Our Ref: F215598

**RE: Variation Of Condition 2 (Approved Plans) Of Planning Permission 21/01957/F –  
Demolition Of GP Surgery And Erection Of 4 No. Dwellings At Doctors Surgery,  
Church Walk, Burnham Market, Kings Lynn, Norfolk**

Project  
**Former Doctors Surgery,  
Church Walk,  
Burnham Market.**  
Title  
**Proposed Floor Plans  
Plot 4**

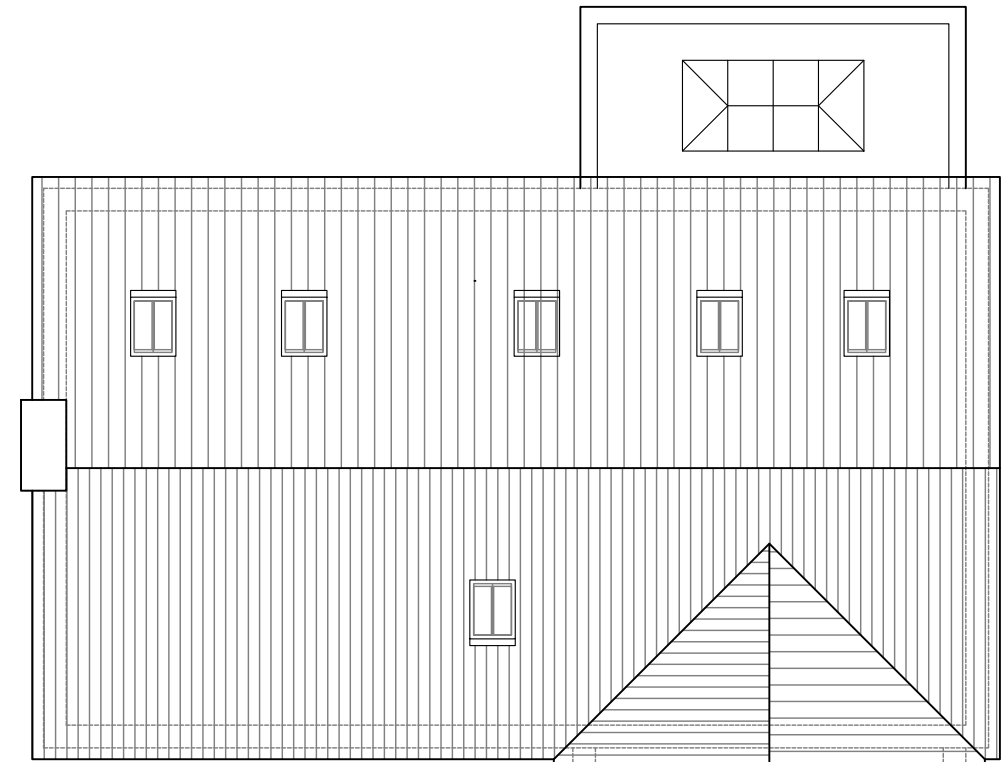
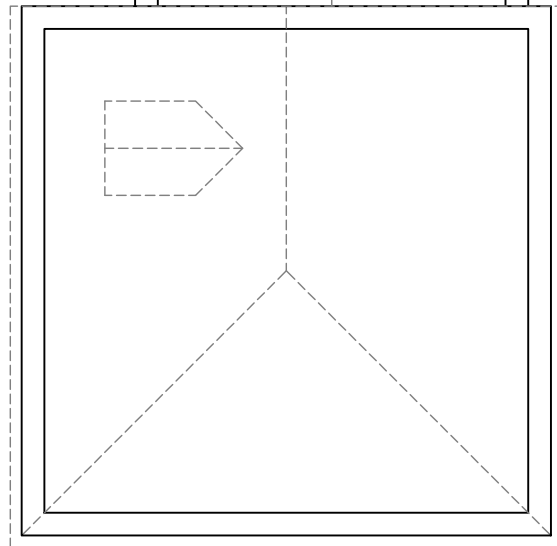
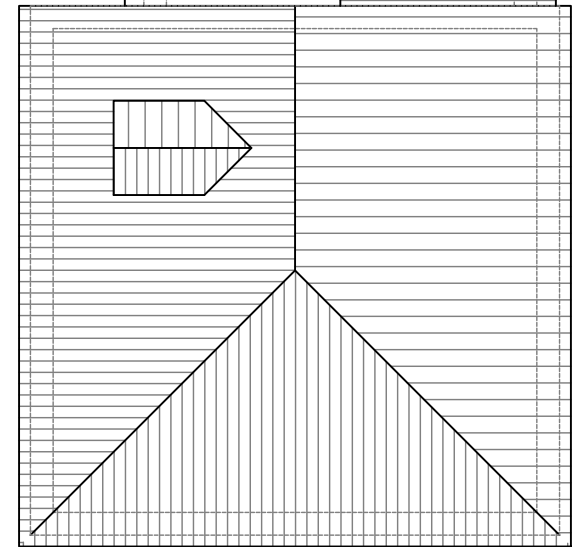
**Plot 4 changes:** clear glazed door to the front entrance (correction of design error on the approved scheme); minor adjustments to windows serving ensuite and bathroom on the east elevation and changes to internal positioning accordingly; and other minor internal changes to room layout and wall positions.
